From: Martyn White <Martyn.White@arun.gov.uk>
Sent: 23 September 2019 17:40
To: Planning.Responses <Planning.Responses@arun.gov.uk>
Subject: AL/70/19/PL

AL/70/19/PL

Change of use from dwelling house (C3 dwelling house) to residential care home (C2 residential institutions) to provide 9 No. bedrooms, kitchen & dining & new rear sun lounge.

Ground Floor Plan & Elevations as proposed

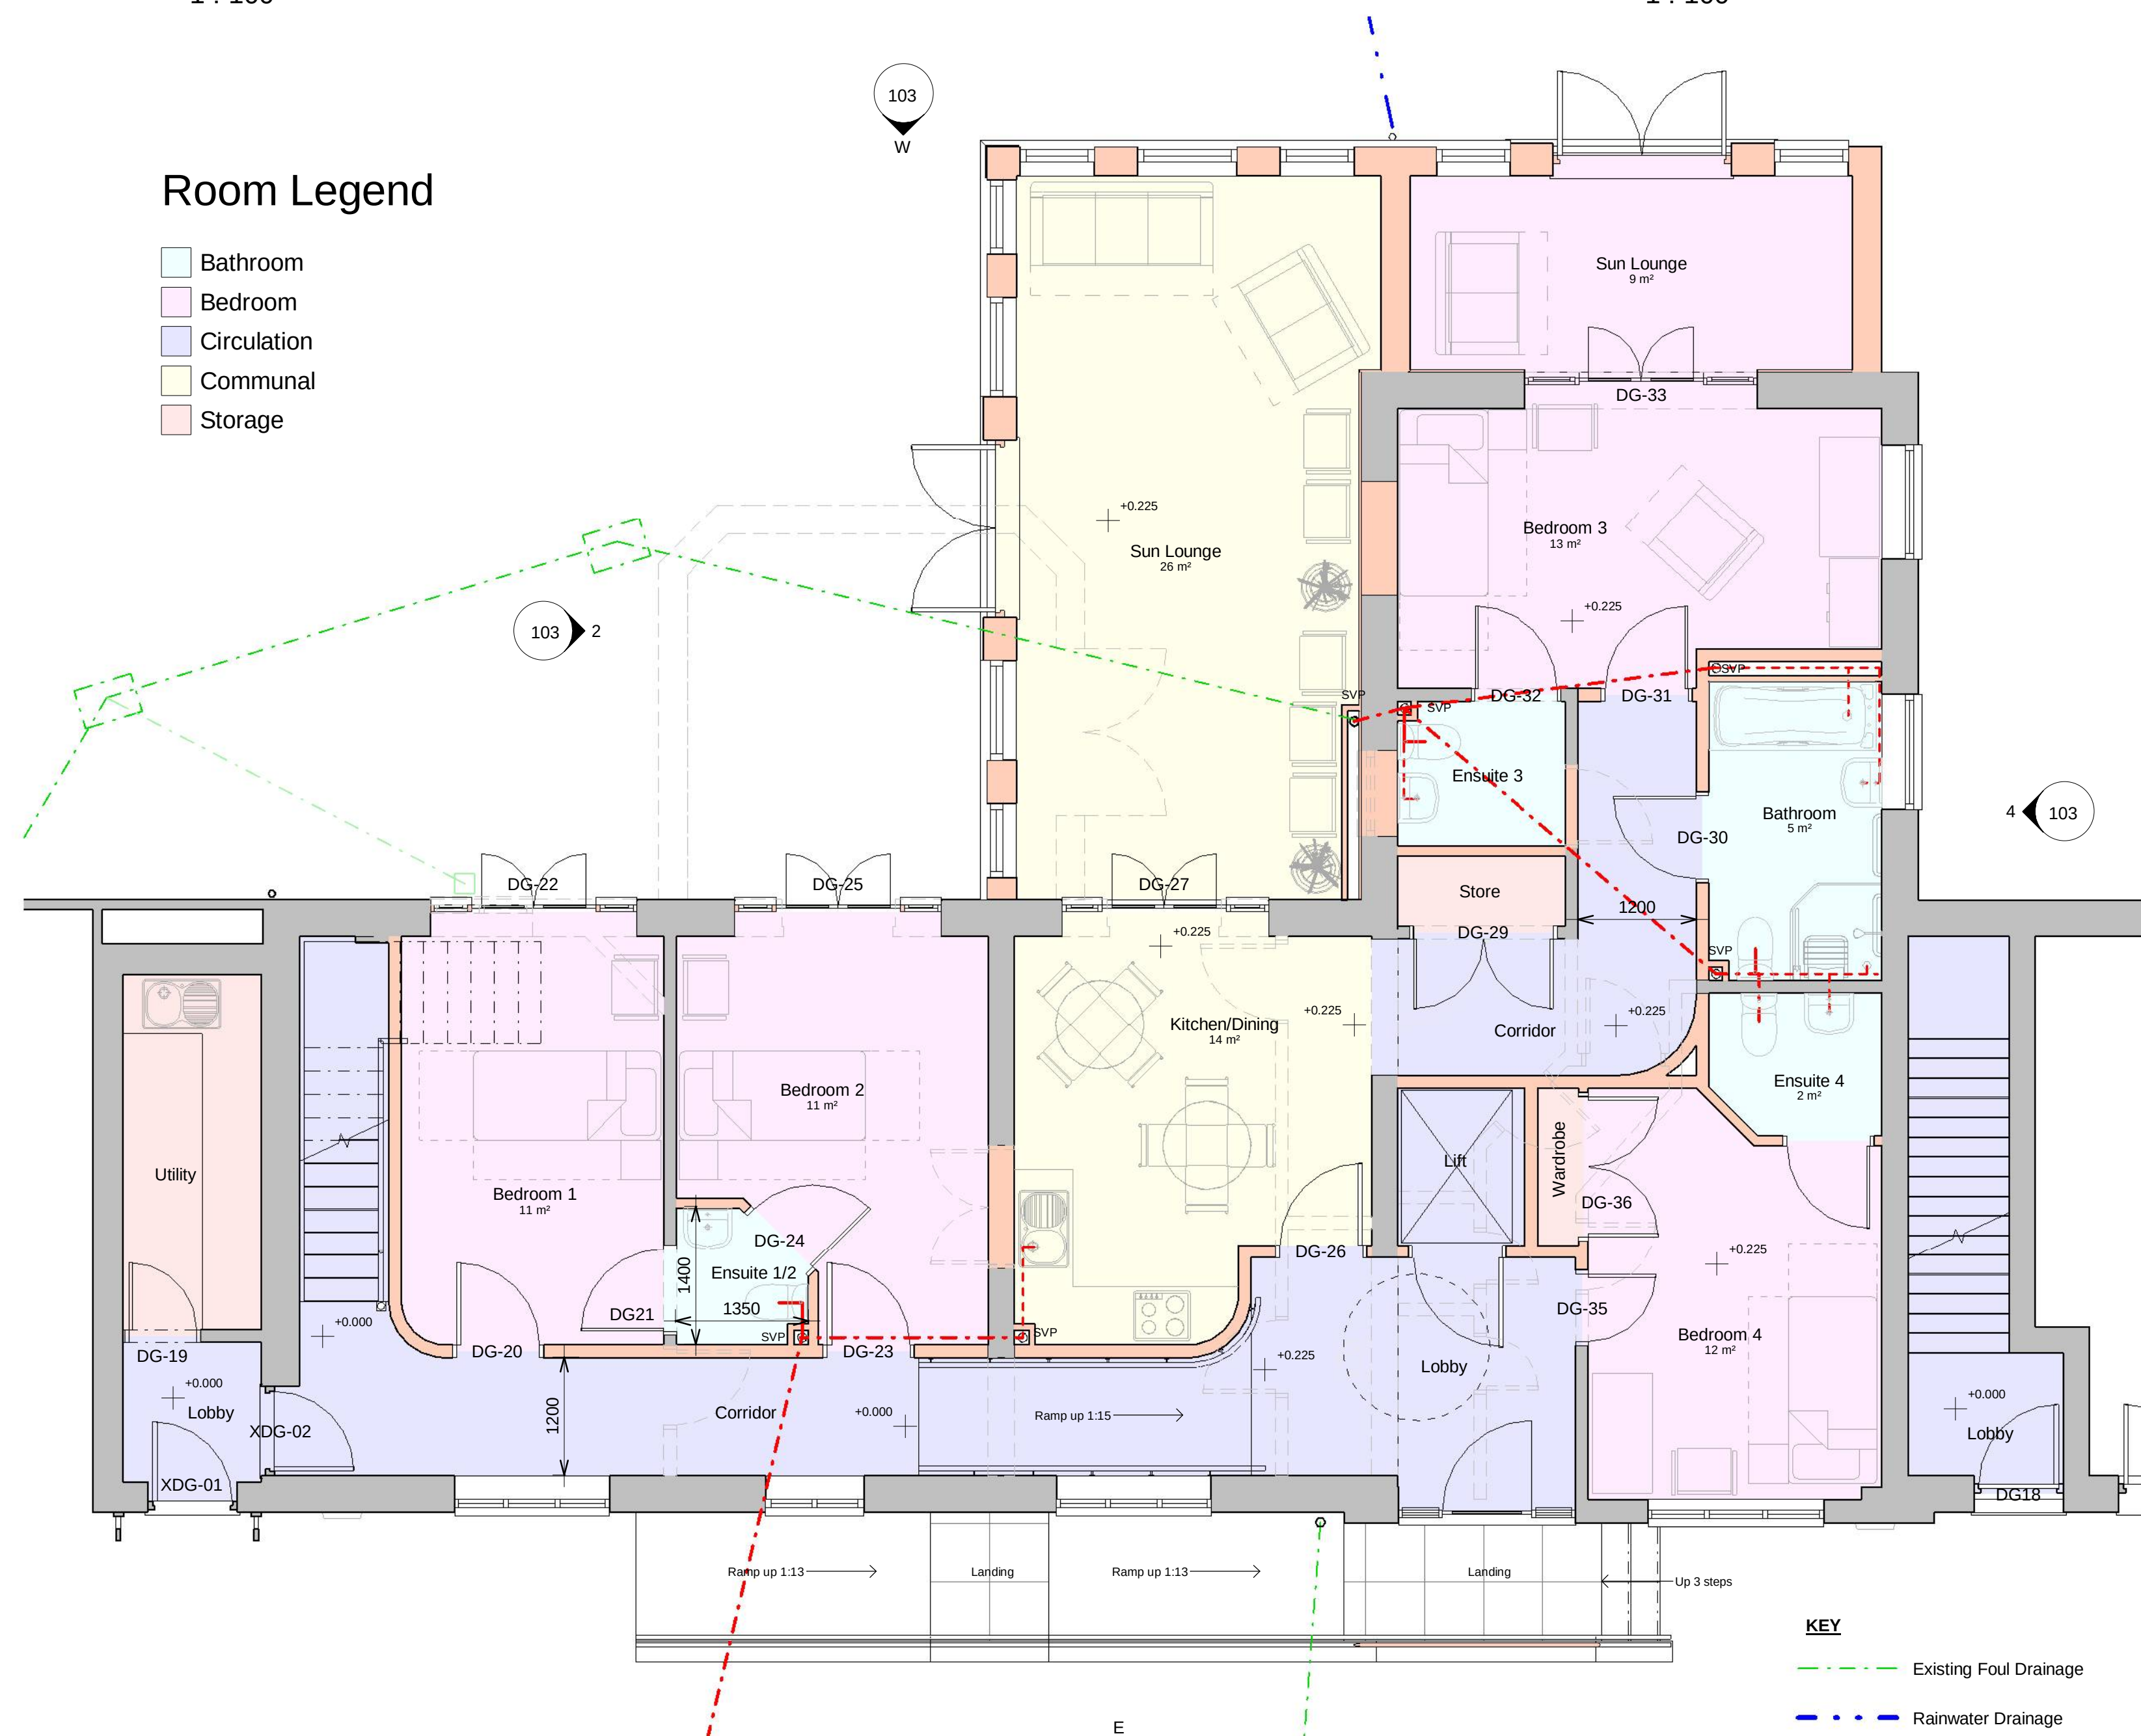
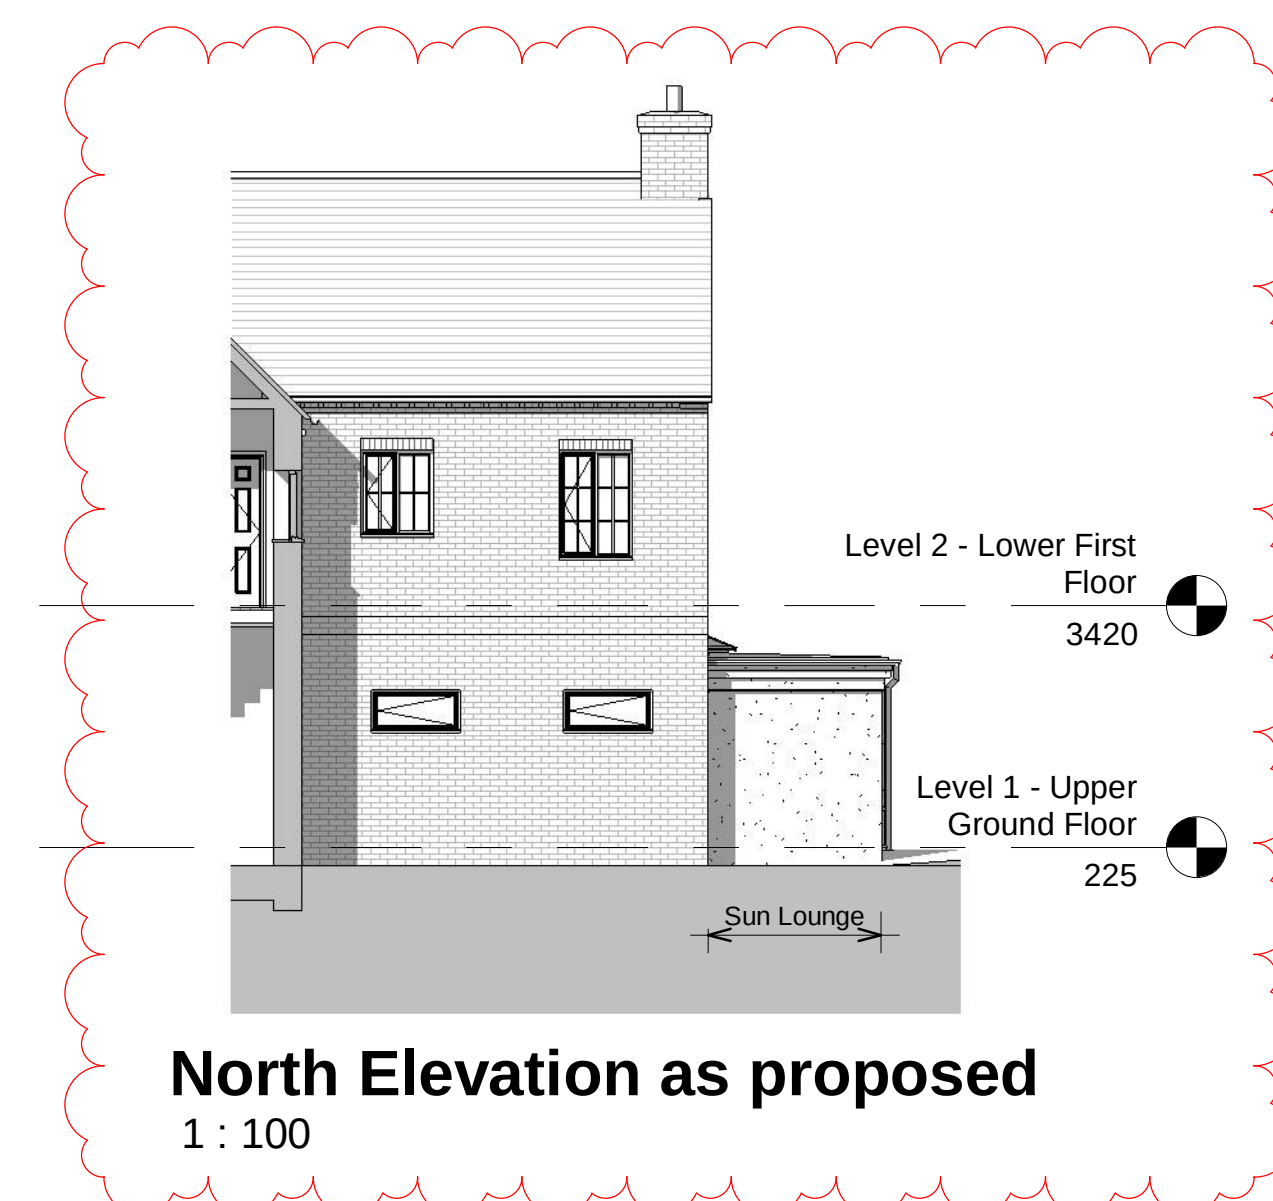
The building has been extended through the introduction of a modern, prefabricated conservatory structure. The design and use of this structure do not relate well to the building itself, and its removal is supported. The proposal to introduce a larger extension in a design more akin to its existing appearance is an enhancement. The success of such a scheme would be dependent upon the use of materials and the proposed joinery. Details of which could be provided to the LPA by way of condition.
